Memo

Colne Valley Viaduct South Embankment Wetland Ecological Mitigation Site

This memo provides additional background information in relation to the ecological baseline and proposals to address comments on the Schedule 17 application that have been raised by London Borough of Hillingdon.

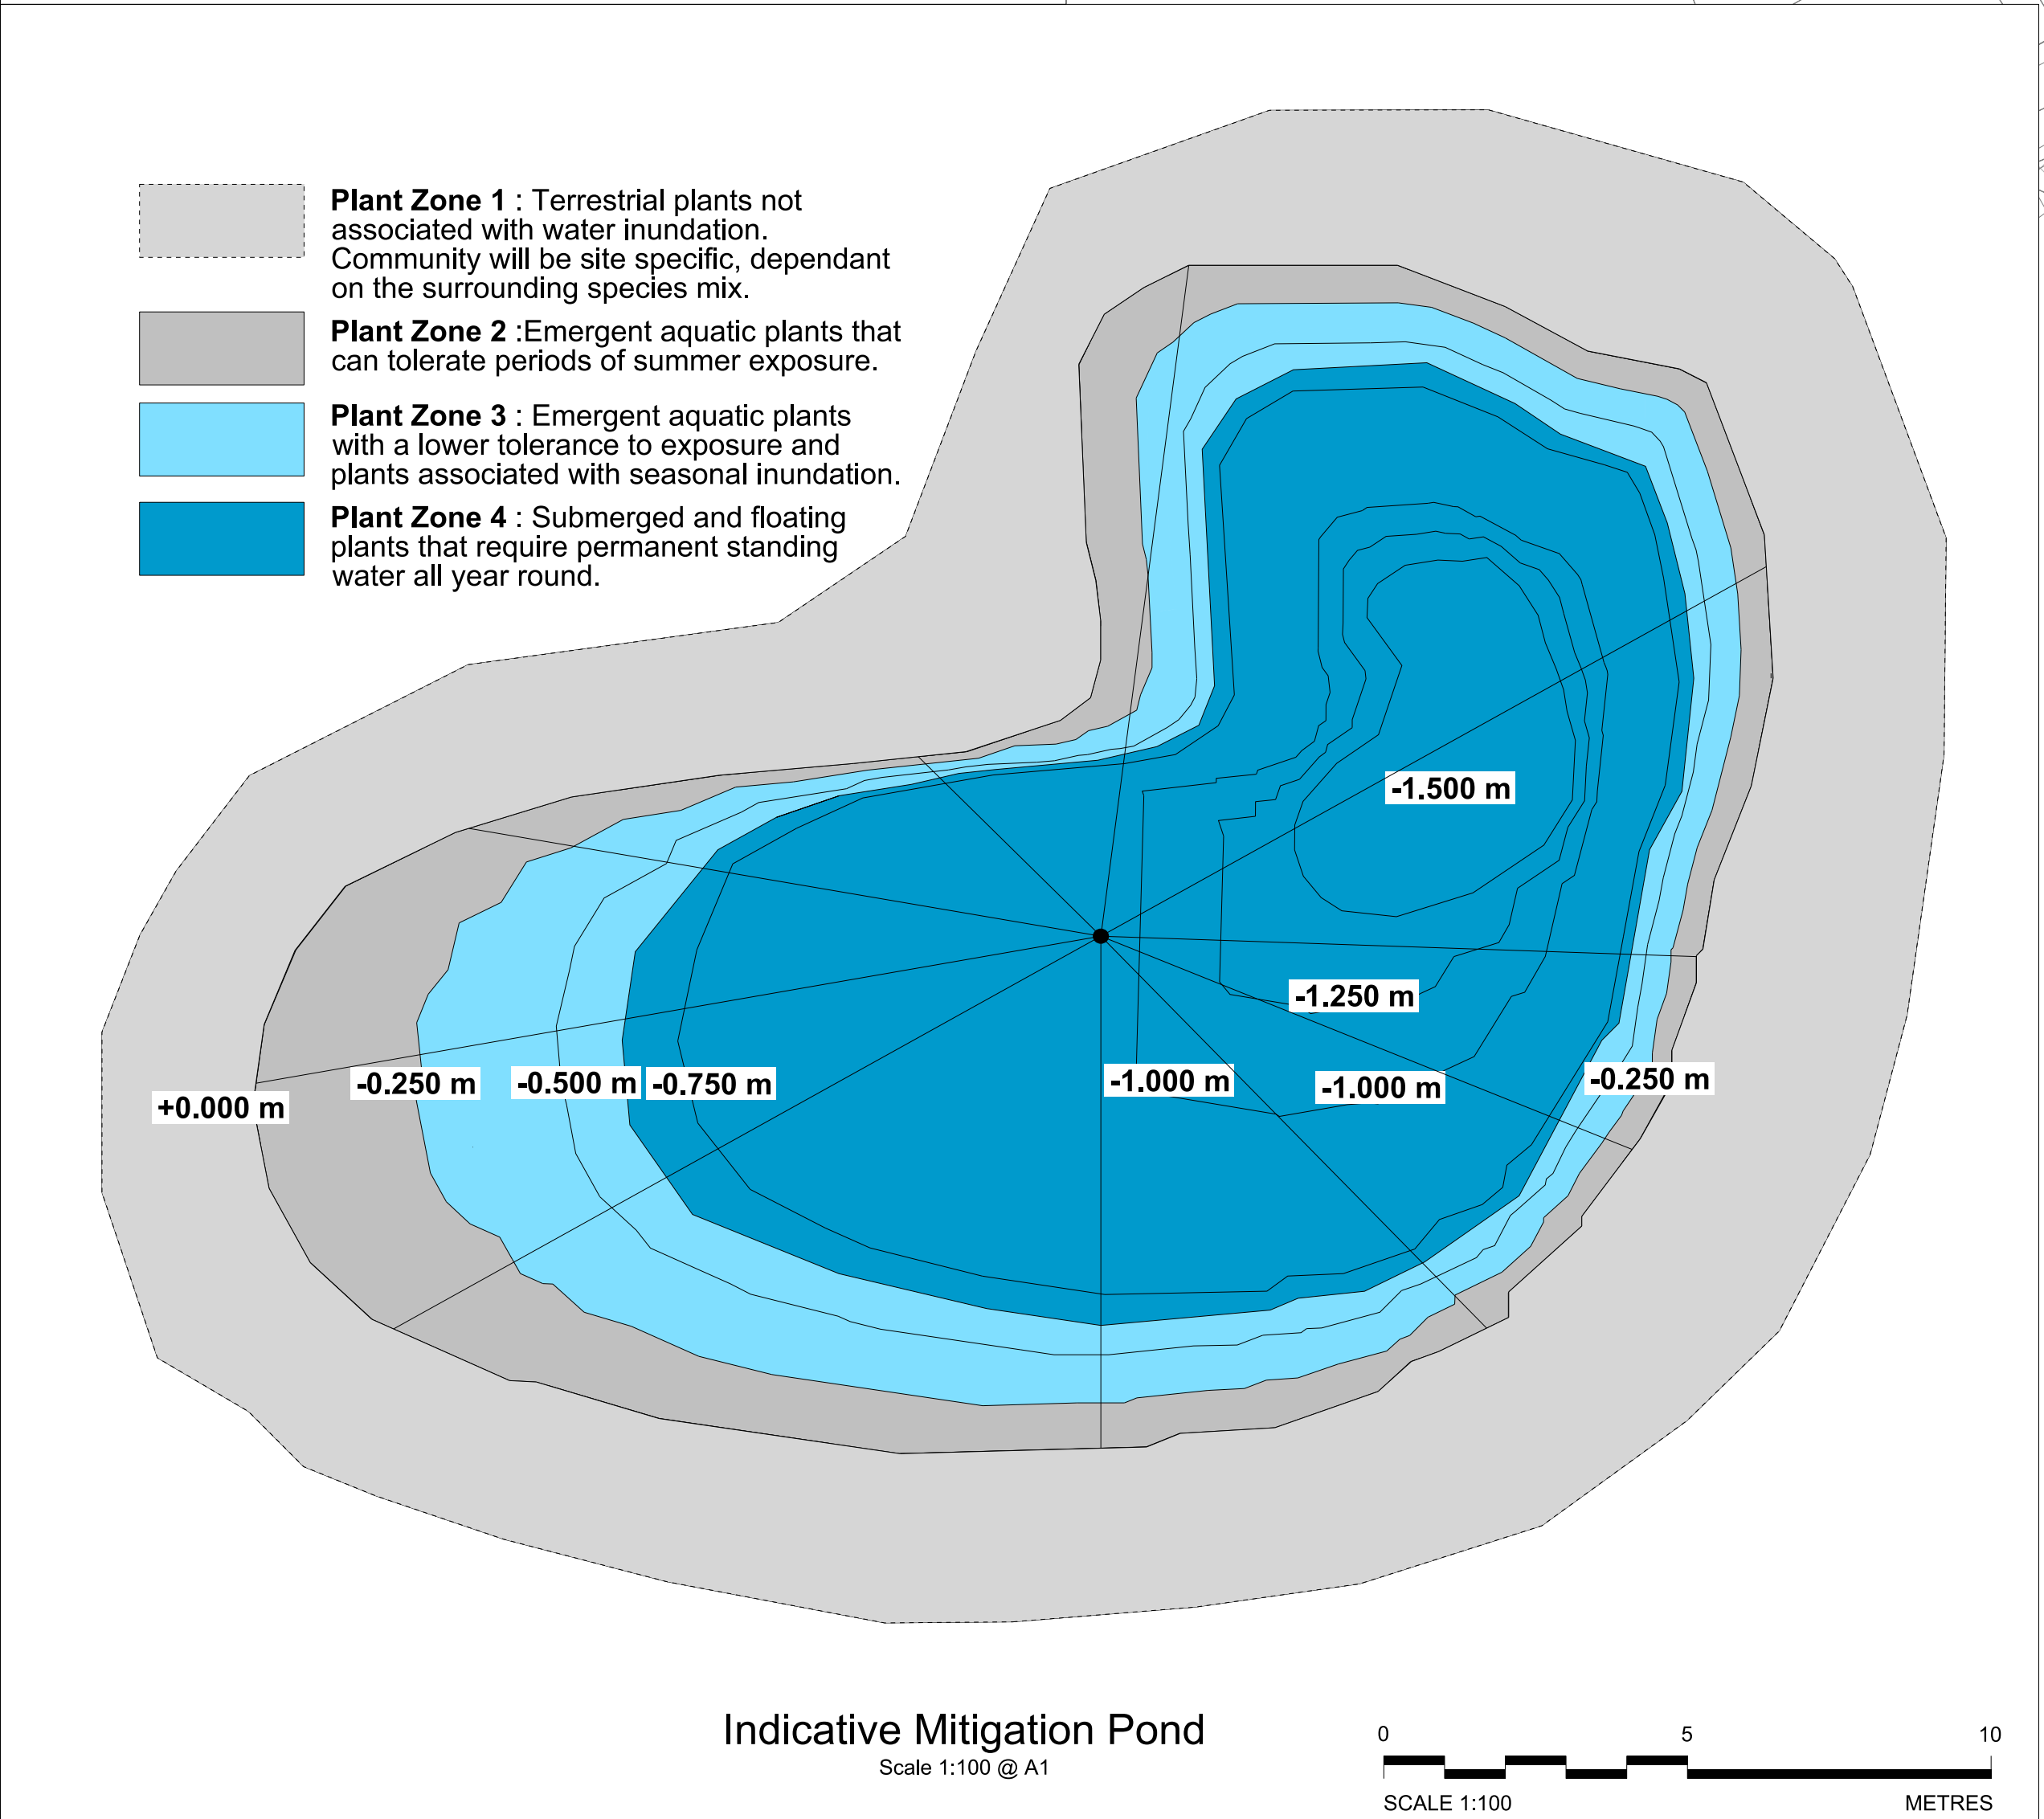
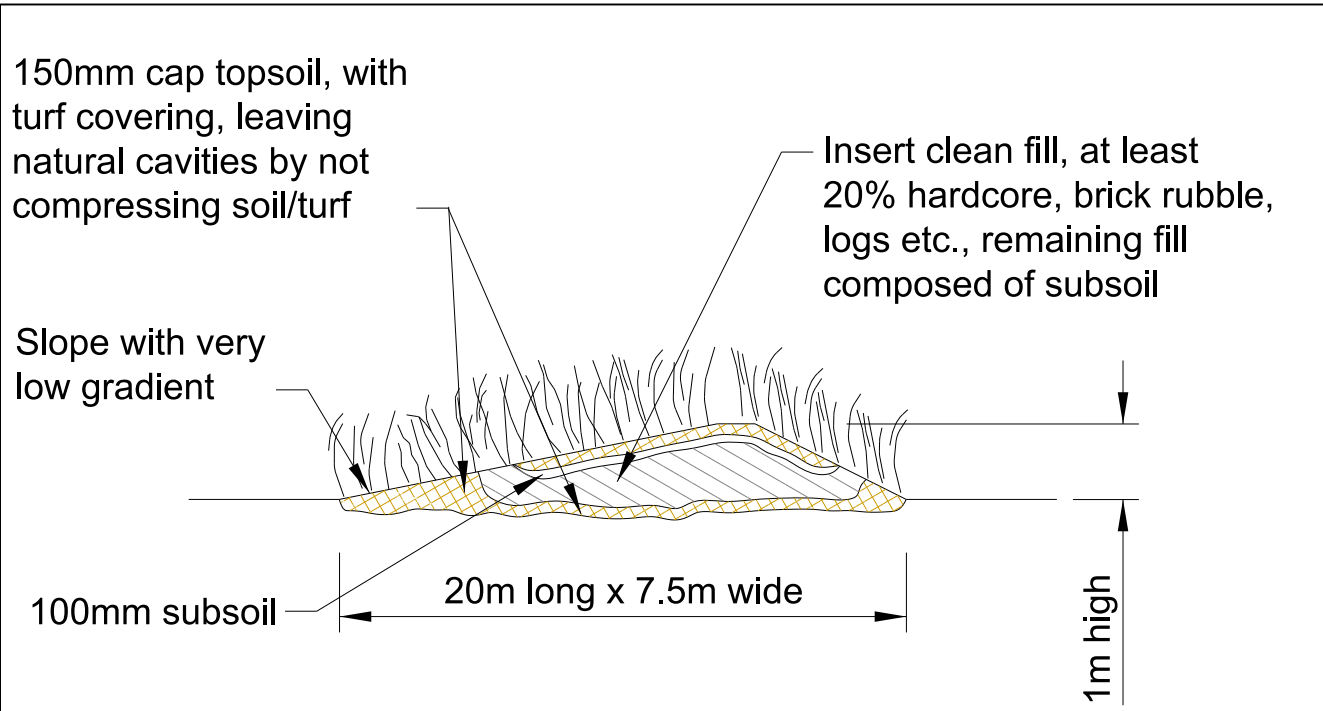
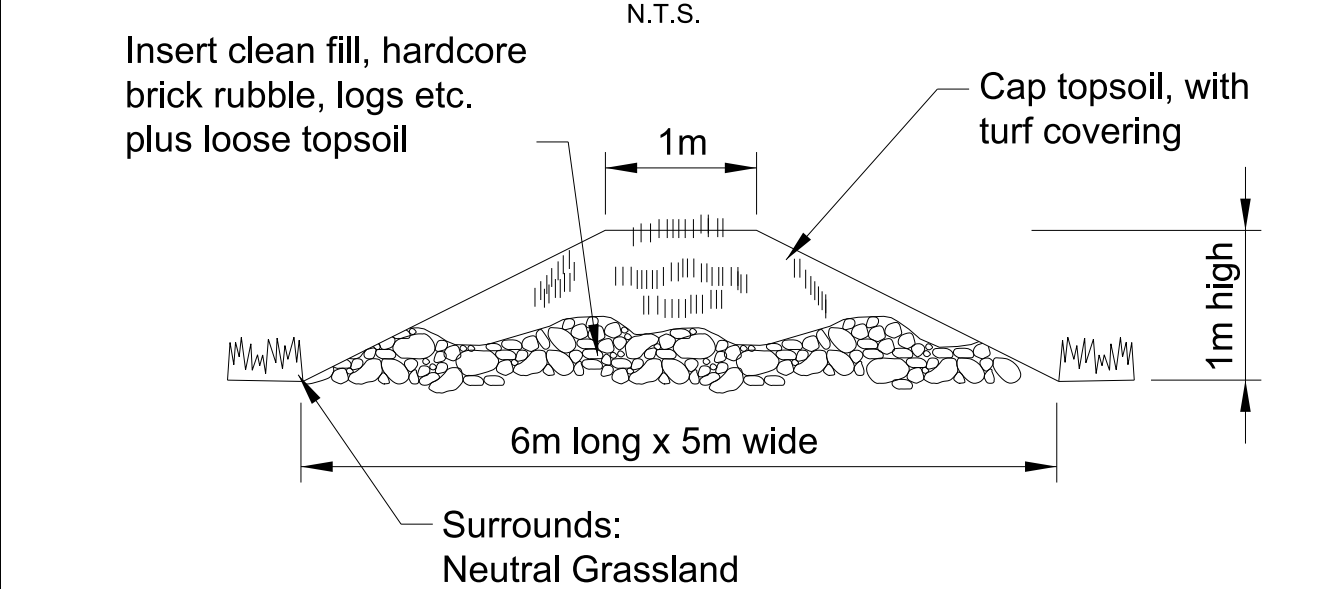
Within London Borough of Hillingdon's response to the Schedule 17 application it is stated that the Mitigation Site now sits within the boundary of the Mid Colne Valley SMI (rather than adjacent to it). A plan provided by London Borough of Hillingdon (see Figure 3) suggests that the boundary of the SMI has been revised since 2013 to include the area of field that was identified for use as a Mitigation Site.

LB Hillingdon have requested that as approximately 0.28ha of the Mitigation Site (total 0.85ha) lies within the SMI and local planning policy is to preserve SMIs that evidence is provided that the construction of the Mitigation Site will not be contrary to policy.

The proposal for the part of the Mitigation Site that we now understand to fall within the SMI is to encourage the development of a wet grassland sward. Details accord with all the relevant HS2 standards and specifications and here it is envisaged that the standing vegetation be cut to around 50mm, the arising removed and then the area oversown with an appropriate commercial wet grassland seed mix. London Borough of Hillingdon have been separately consulted on the wet grassland seed mix to be utilised as part of the bringing into use consultation.

The proposals also include the construction of two hibernacula suitable for great crested newts and reptiles within the area that falls within the SMI. The construction of these hibernacula will result in *de minimis* loss of habitat and provide enhanced habitat for amphibians and great crested newts in particular, which may in due course be translocated into the Mitigation Site from ponds lost to HS2.

The pond and reptile basking bank are to be constructed in the part of the Mitigation Site outside of the SMI and the topsoil from construction of the pond used to construct the basking bank and hibernacula. The subsoils will be spread

thinly over the area of the Mitigation Site outside of the SMI. Spreading of the subsoil over the area within the Mitigation Site (but outside of the SMI) is intended to reduce the current nutrient levels in the topsoil to aid establishment of the wet grassland sward.
